The comments of the **Arun District Conservation Area Advisory Panel** are as follows:

Application No: LU/380/21/PL

Site Address: Regency Court Nursing Home 18-20 South Terrace Littlehampton BN17 5NZ

Description of Works: Replacement of 1 No PVCu window with a timber window to the rear (East) elevation. This application may affect the setting of a listed building, affects the Littlehampton Sea Front Conservation Area & is in CIL Zone 4 (Zero Rated) as other development.

Clients: Aster Court Nursing Home	
18-20, South Terrace, Littlehampton, BN17 5NZ	
Proposed New Window Details	
Scale: 1:20	Note: drawings not to be scaled from. Drawings are issued for planning purposes only.
GBS Design Services	Tel: 07918 638 510
20 November 2021 Geoff Brown MCIAT AssocRICS

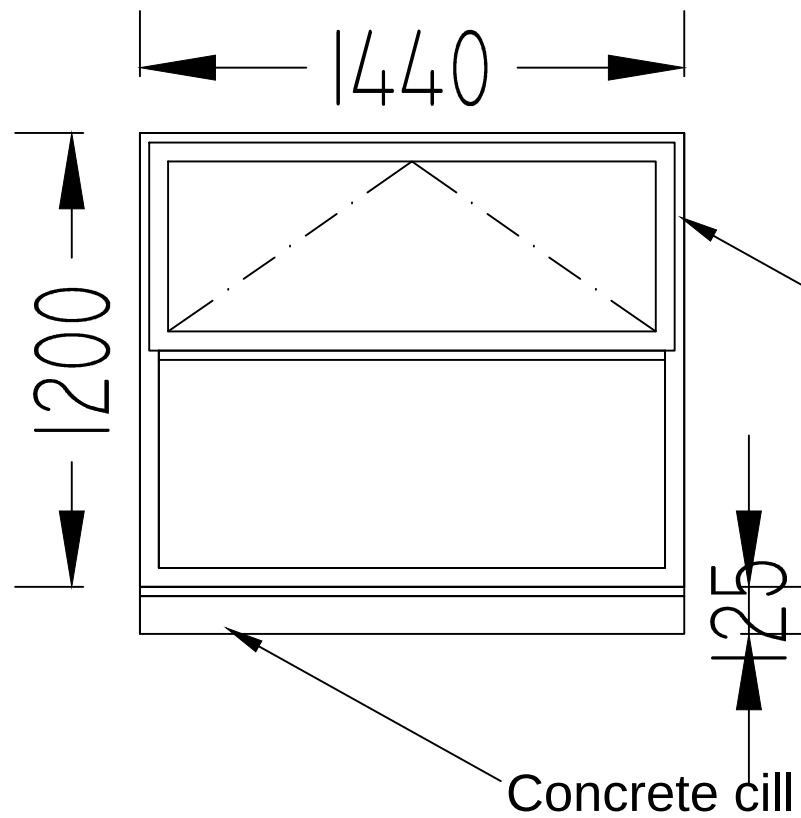
The replacement of the pvcu window with a timber one (assumed to be painted white) is welcomed.

Given the regency style of the building, a vertical sliding sash window would be more appropriate than the top hung example proposed but there are limited views of the east elevation from public areas within the conservation area. It is assumed that the majority of the remaining windows in this elevation are top hung sashes but if they are vertically sliding sash windows then the Council should insist on the latter type for the replacement window.
